Address: 68 Cliffe Lane Cleckheaton Bd19 4eu

Application number: 2021/90212	
What is the application for?:	Variation condition 2 (plans) on previous permission 2017/91597 for Listed Build
Address of the site or building:	Egypt Farm, Cliffe Lane, Gomersal, BD19 4EU
Postcode:	BD19 3HW

Eastern Elevation 1: 100

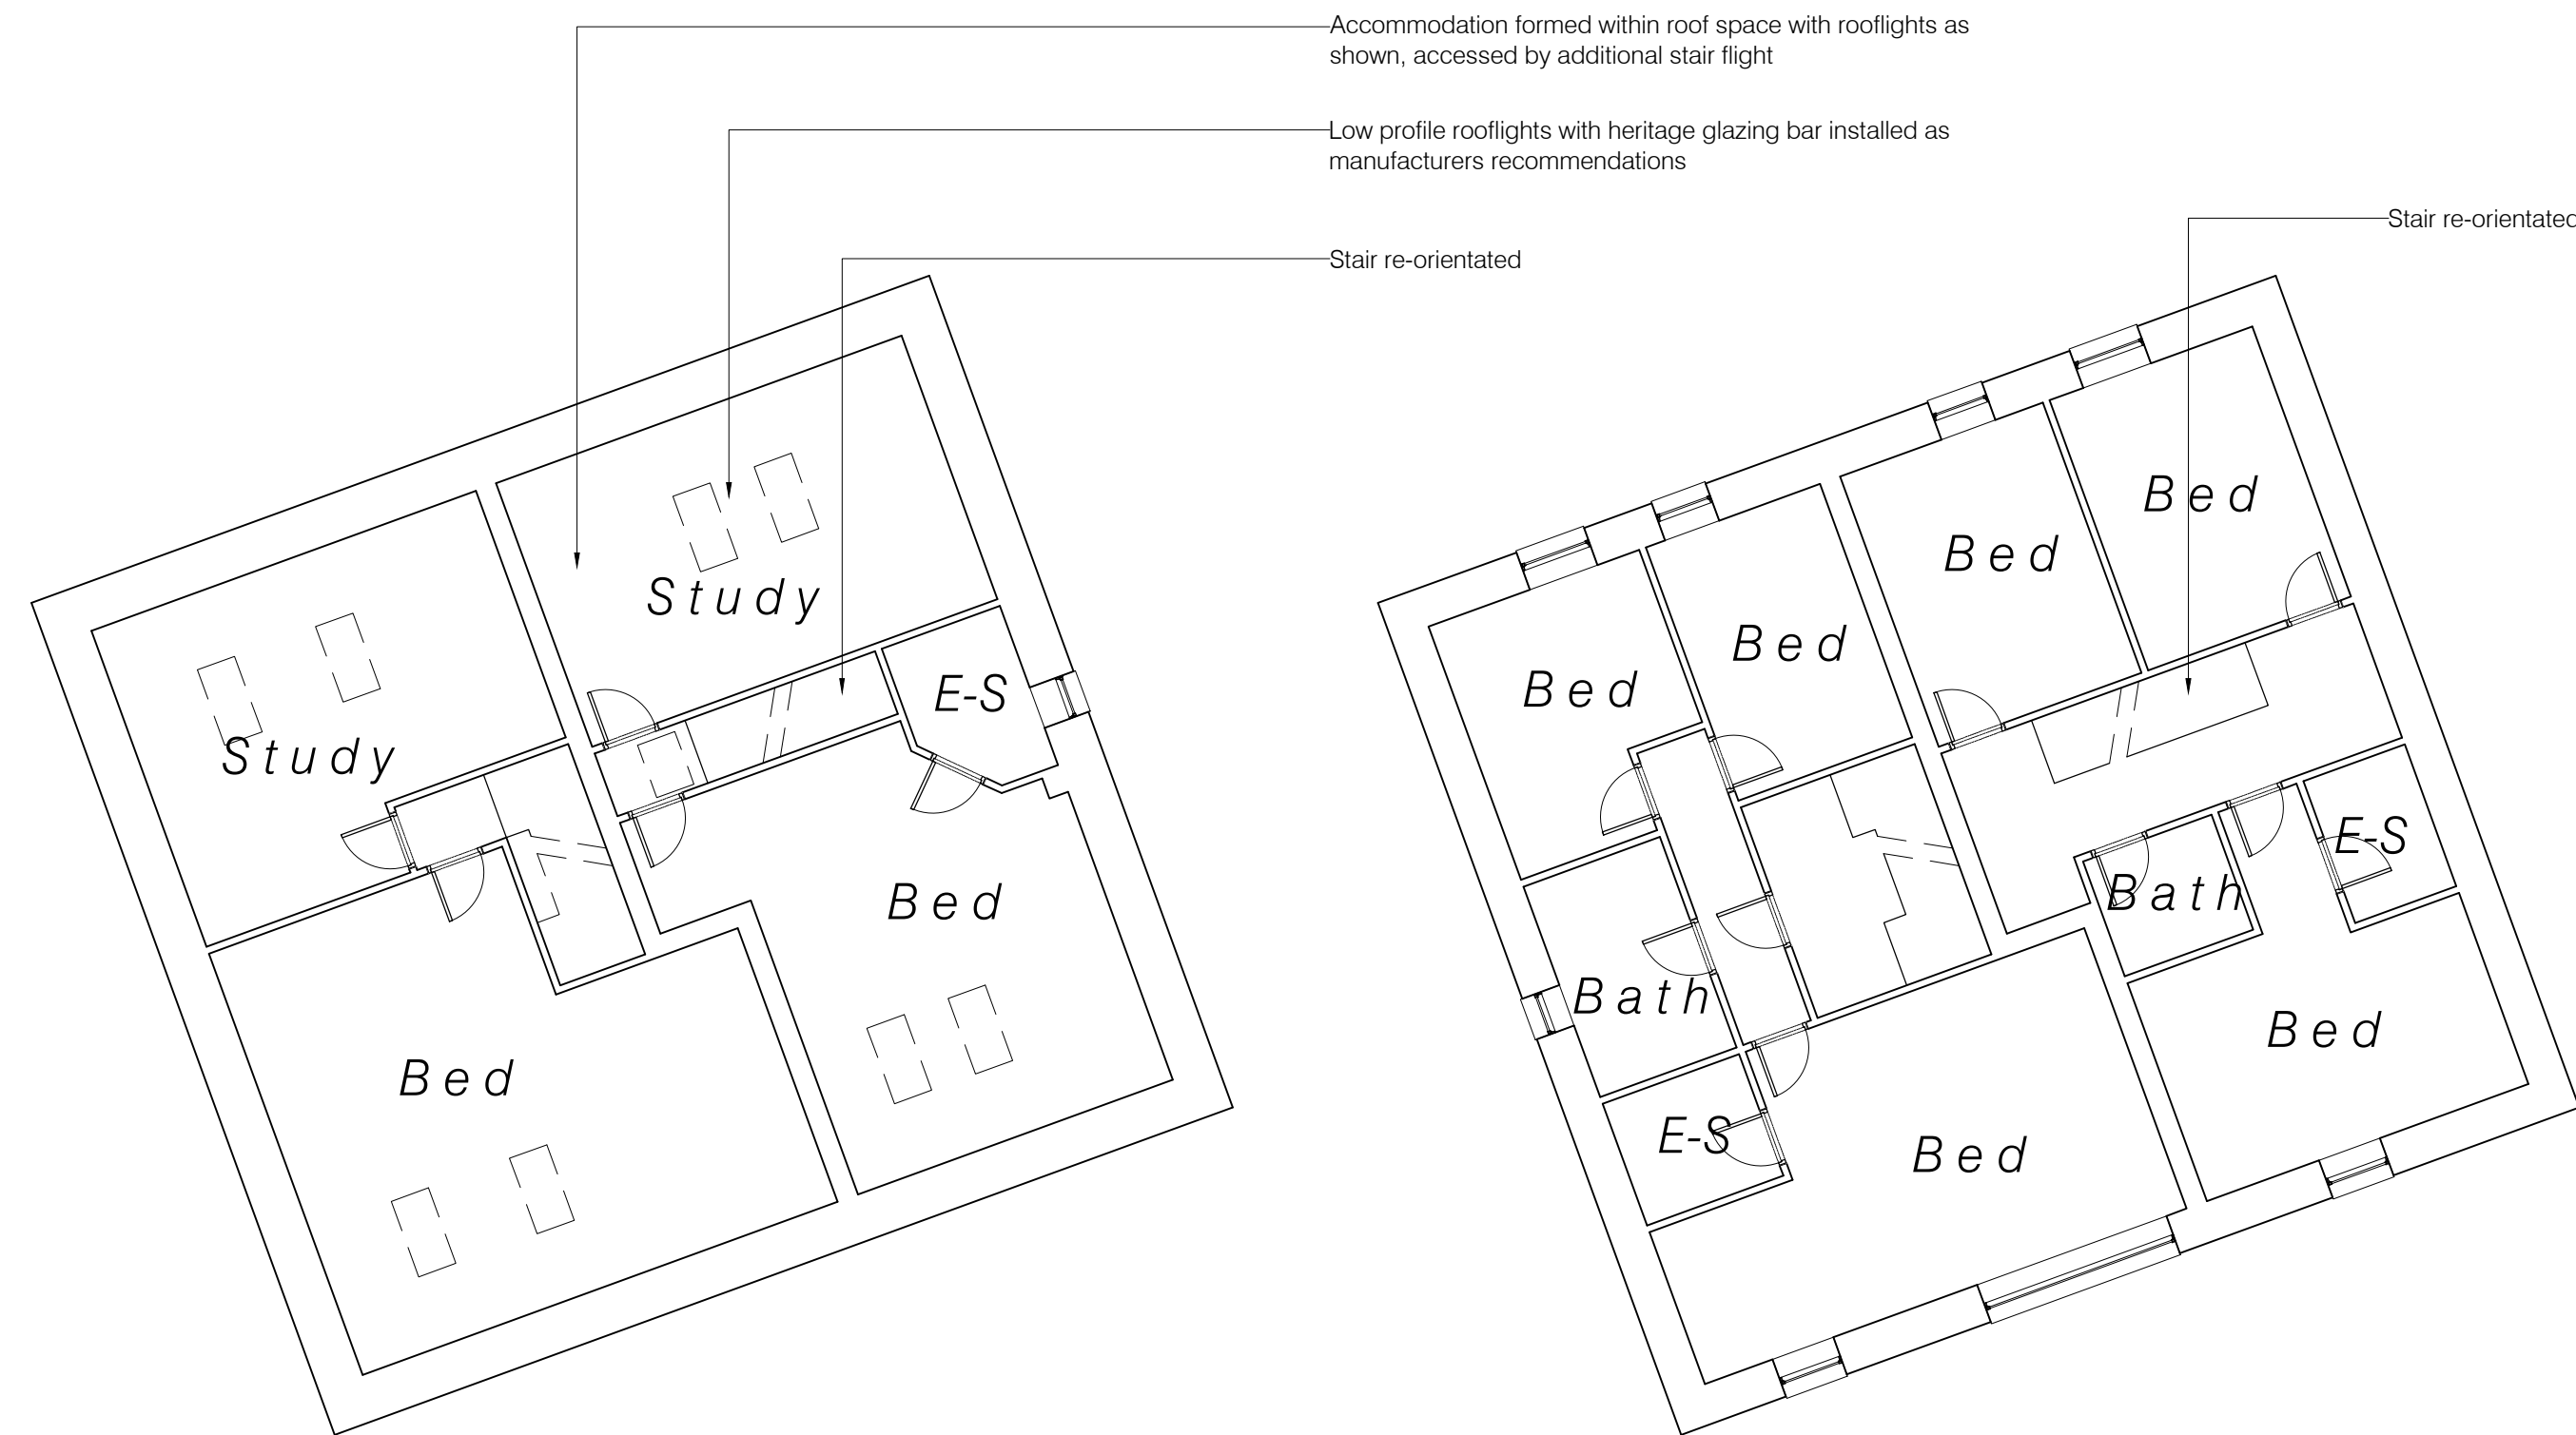
Type of comment: An objection	
Do you wish your comments to be published on the website anonymously?	No
<p>We would like to object to this planning application.</p> <p>We would be grateful if you would take into consideration the following points.</p> <p>ALL OF THE POINTS RELATING TO ADDITIONAL OPENINGS AND AN ADDITIONAL FLOOR WERE REFUSED AND REFUSED ON APPEAL IN PREVIOUS APPLICATIONS.</p> <p>1. Additional floor level in the barn.</p> <p>Previously refused and refused on appeal.</p> <p>2. 11 Additional sky light windows.</p> <p>The arrangement of existing and proposed window openings would detract from the original character of this traditional barn.</p> <p>3. Window at the top of the East elevation overlooking the cottage 60/62 and 64/66 Ye Closes</p> <p>This window is overlooking the house and gardens of both 60/62 and 64/66 the Grade II listed building and adjoining cottage.</p> <p>4. Door in the East elevation.</p> <p>This door opens onto an access track which is used by agricultural vehicles &amp; pedestrians using the public footpath.</p> <p>5. Objection to re-opening the ground floor window on the East elevation.</p>

This window would overlook both 60/62 and 64/66 the Grade II listed building and the adjoining cottage. These houses have never been overlooked and the original plans where proposed and passed to respect this.

9. Roller shutter in East elevation of the garage.

This industrial proportioned door is positioned opposite residential dwellings numbers 68/70/72 Cliffe Lane. This takes away the privacy these houses were granted if the original plans had been adhered to. This was originally approved as a hay store.

Western Elevation 1: 100

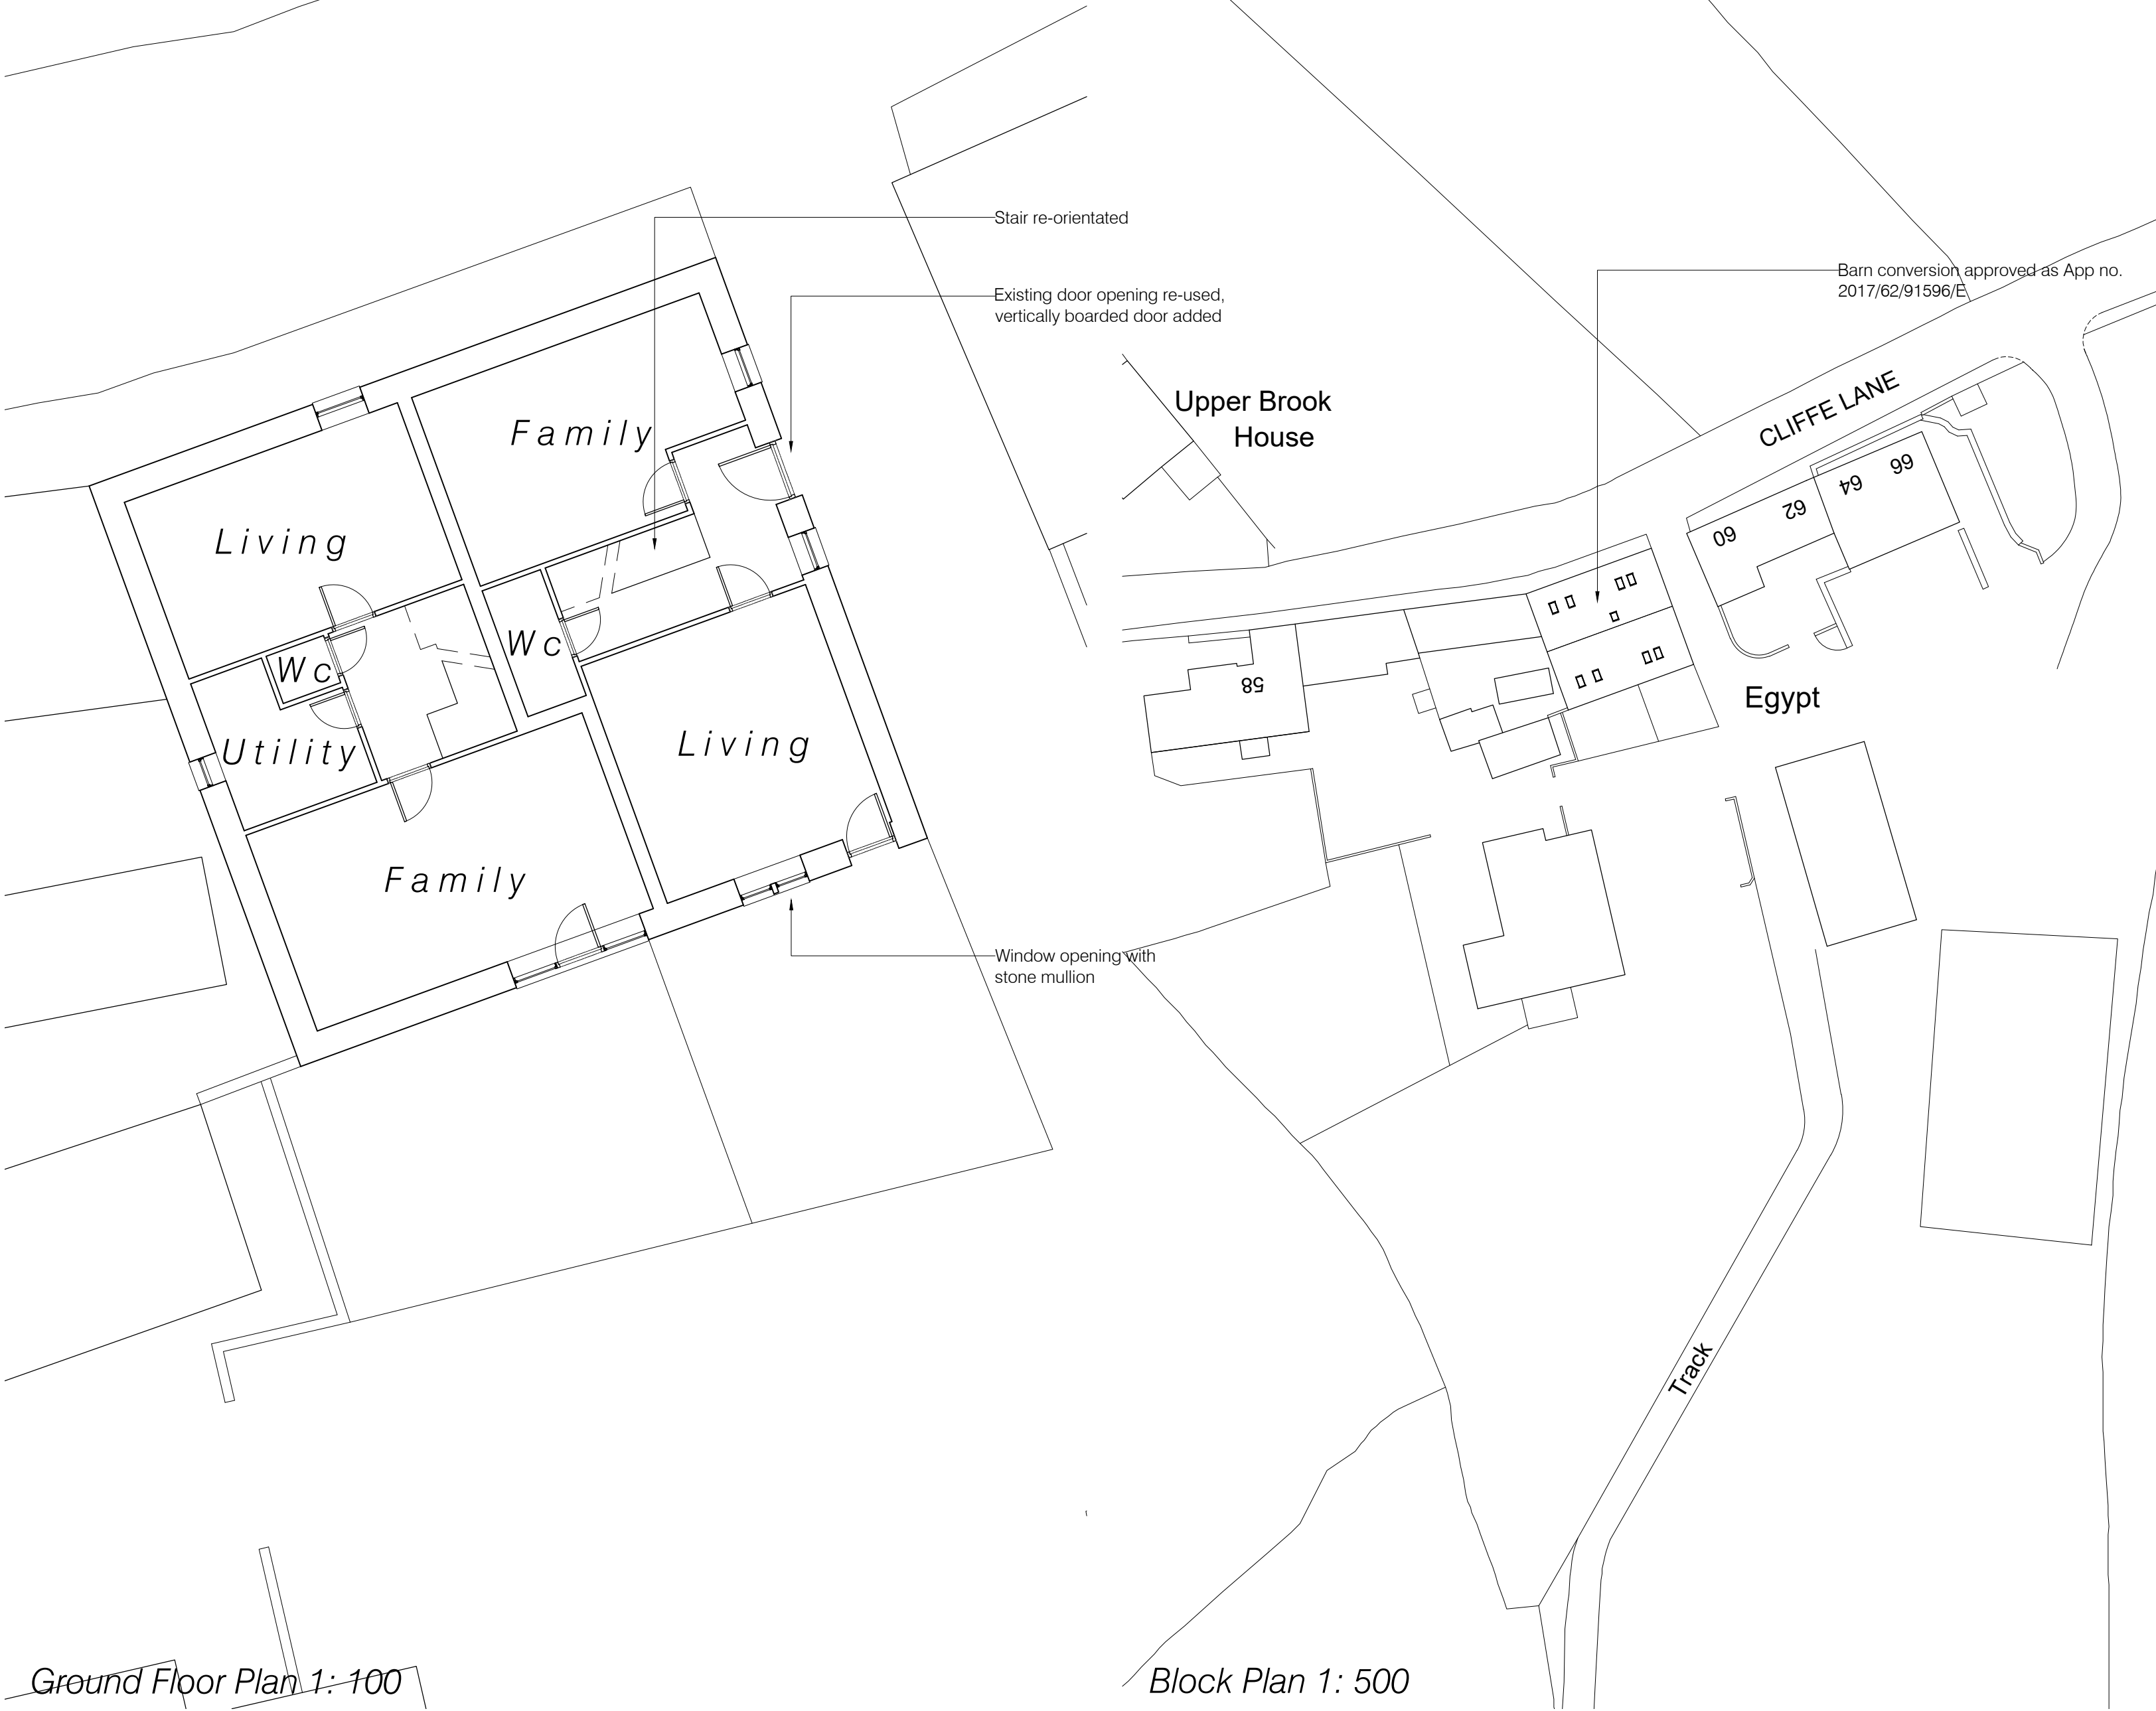
8. 2 windows in the West elevation overlooking 58 Cliffe Lane, Egypt Farm.

2 Additional openings have been made by the developer without planning approval. Egypt Farm has never been overlooked and the previously approved plans respected this.

12. Gas Flue.

Gas flue positioned on the west elevation producing toxic emissions into the adjoining stable.
